**PLANNING ACT 2008
APPLICATION BY HIGHWAYS ENGLAND FOR AN ORDER GRANTING
DEVELOPMENT CONSENT FOR THE A303 SPARKFORD TO ILCHESTER
DUALLING
SUBMISSION MADE PURSUANT TO DEADLINE 5**

PLANNING INSPECTORATE REFERENCE TR010036

SUBMISSION MADE PURSUANT TO DEADLINE 5

Action 8 - Report of discussions between the parties on potential design change on road passing Camel Hill Services and other proposed cul-de-sacs

**WORK NO 5
(PODIMORE TURNING HEAD)**

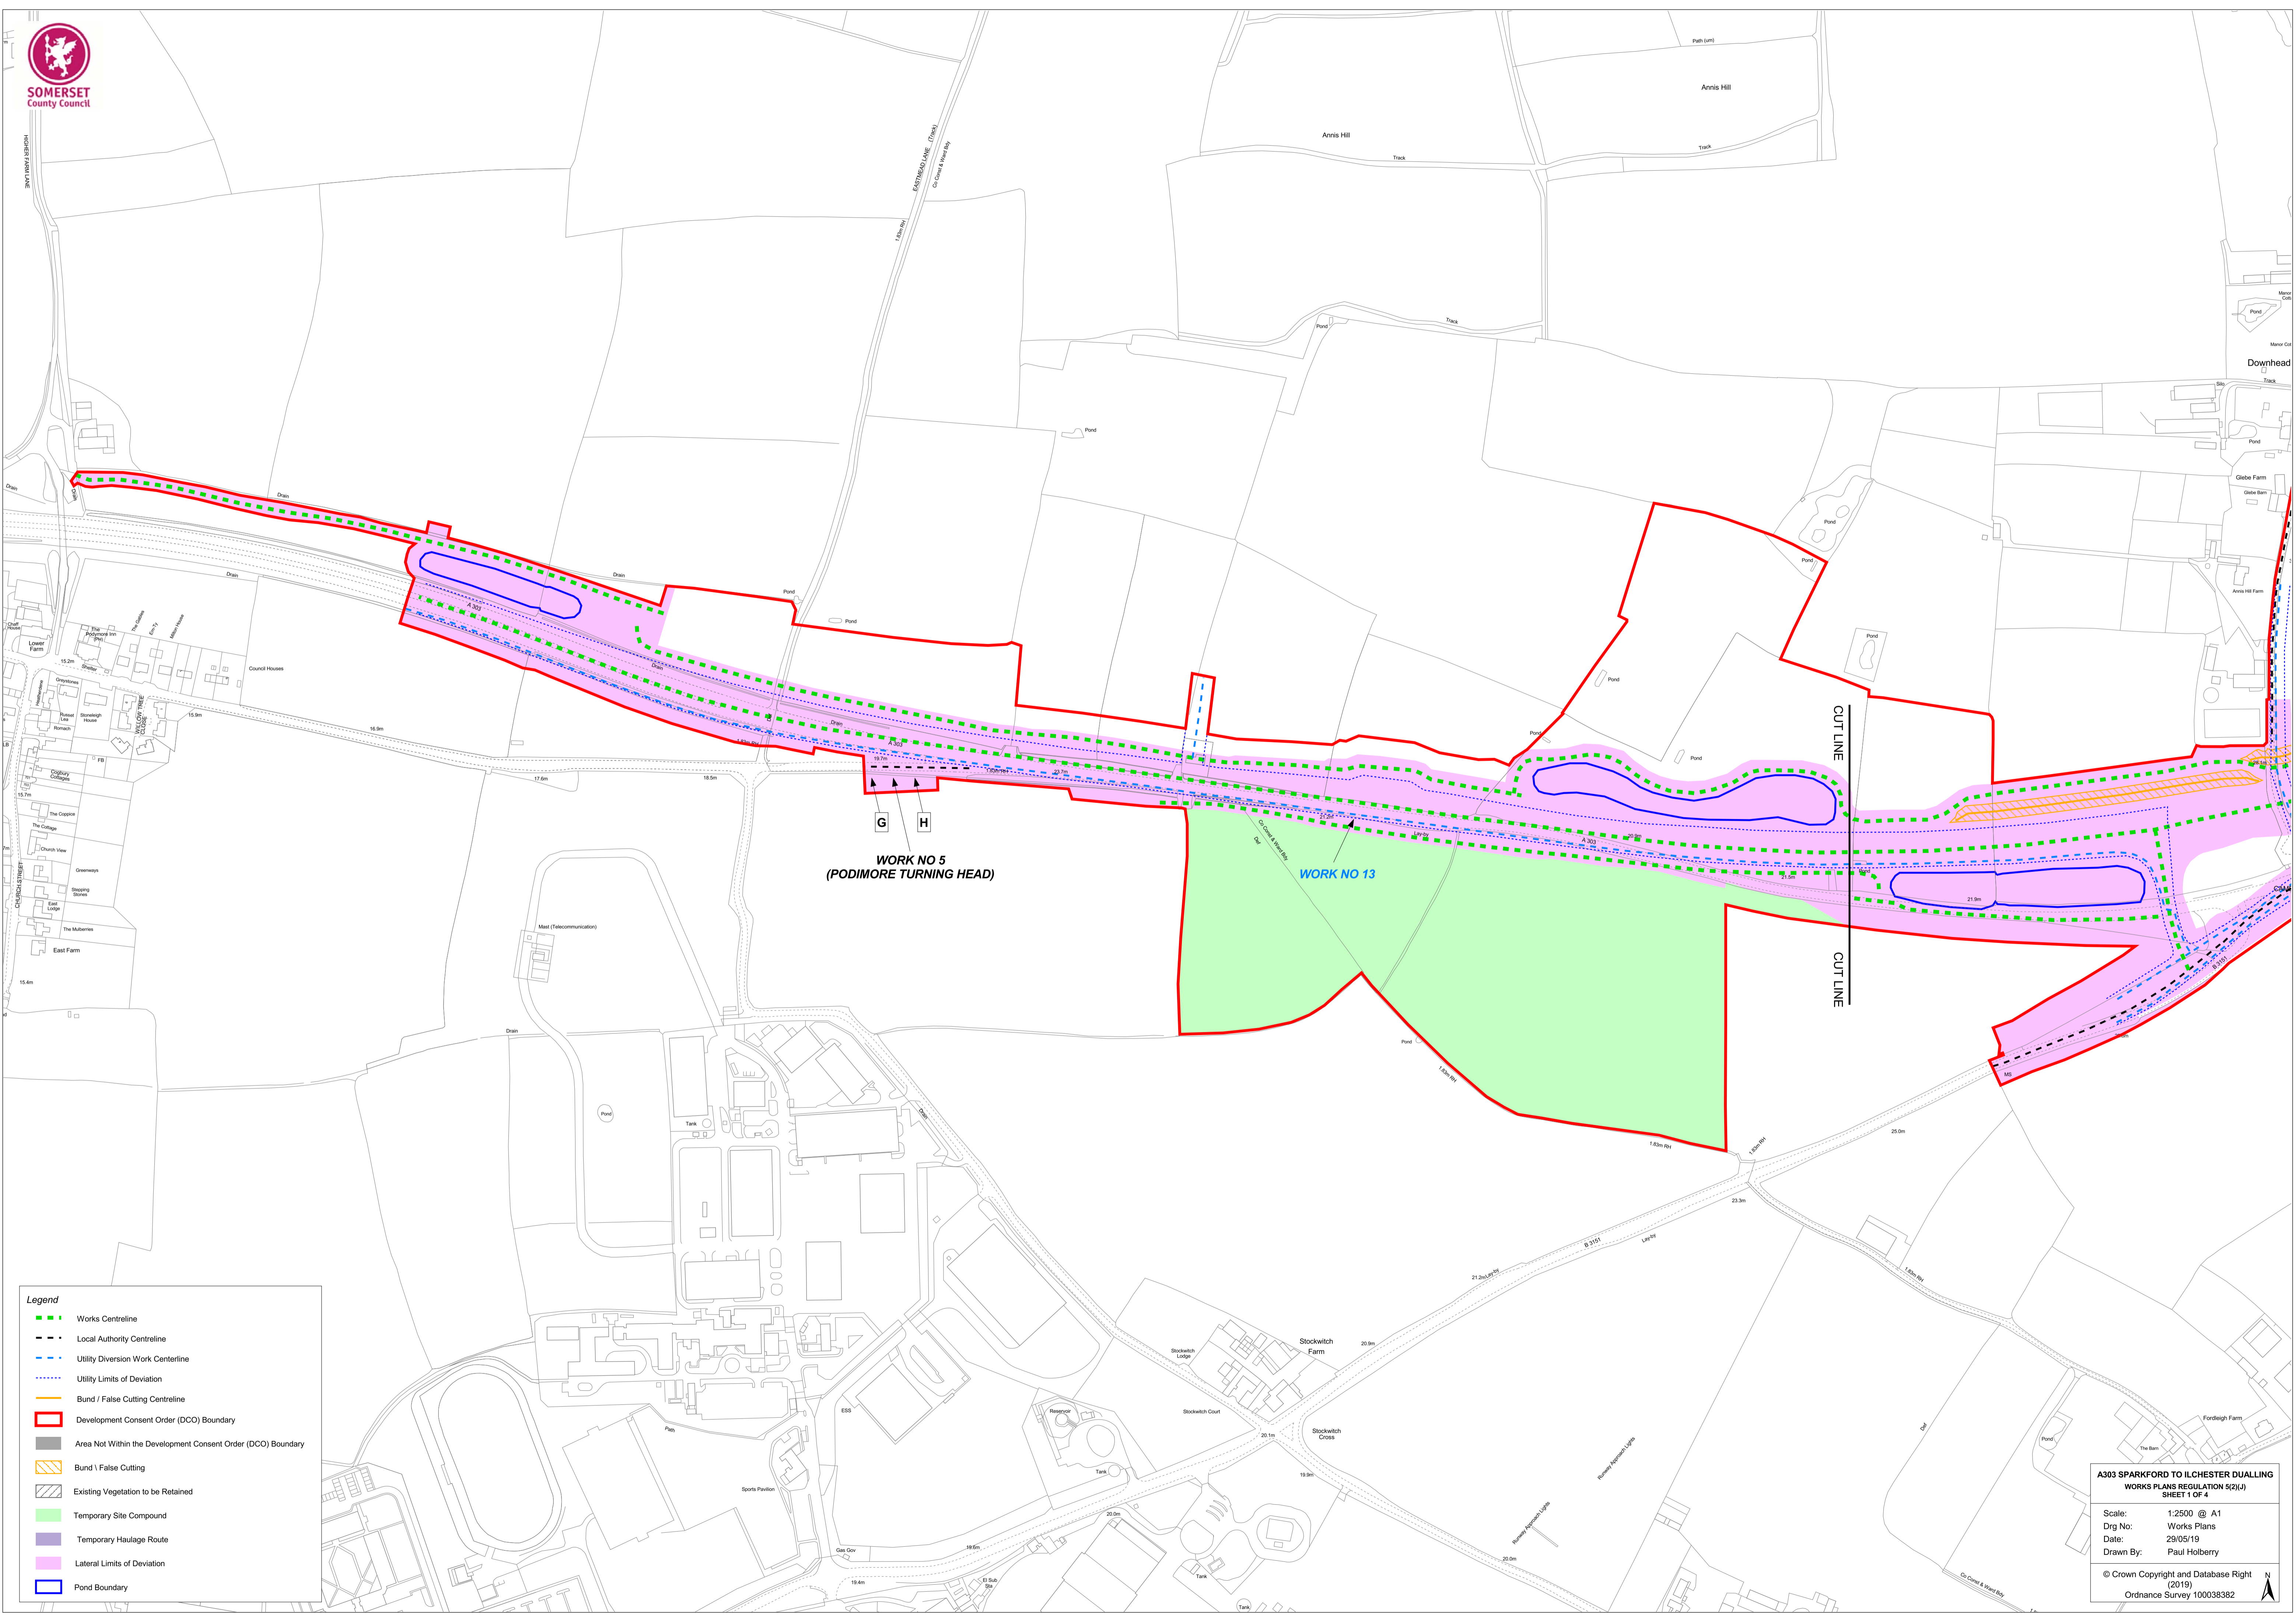
2. Podimore Road & proposed turning head

- In its Local Impact Report (LIR) representation (ref P5), the County Council considered that the construction road between Steart Hill and Camel Hill and Tracks 4 & 9 would further serve to provide a Non-Motorised User (NMU) route across the scheme, were they to be designated as public bridleway or restricted byway. However, an additional link would be required between the proposed Podimore turning head and the minor road to the west to facilitate this.

- Since submission of the LIR, it has been noted that the DCO boundary does not extend beyond the proposed turning head to the West, yet such a facility would not in practice be possible to use given the existence of a Traffic Regulation Order (TRO) preventing the flow of traffic from the junction of Stockwich Lane and Podimore Road towards the existing A303. Indeed, the associated TRO would prevent access by even pedal cyclists and equestrians, not just motorised vehicles.

- In addition, there is a significant risk that such a cul-de-sac may be used as an unauthorised traveller encampment.

- At the Issue Specific Hearing on Traffic and Transport on 26 February 2019, the County Council sought that the highway between the existing A303 and the junction of Stockwitch Lane and Podimore Road should be stopped up and the land turned to green field. All highway rights should also be removed unless the Applicant was willing to accede to the County Council's request for an NMU route between Access Track and Podimore Road, in which case appropriate rights would need to be retained. The associated TROs would also need to be revoked.

- It is understood that the Applicant is developing outline design details in relation to the Podimore slip that should help to address the County Council's concerns on this matter, and that it would be willing to enter into a S278 agreement to secure the necessary works outside the development boundary. An update on progress will need to be provided at Deadline 6
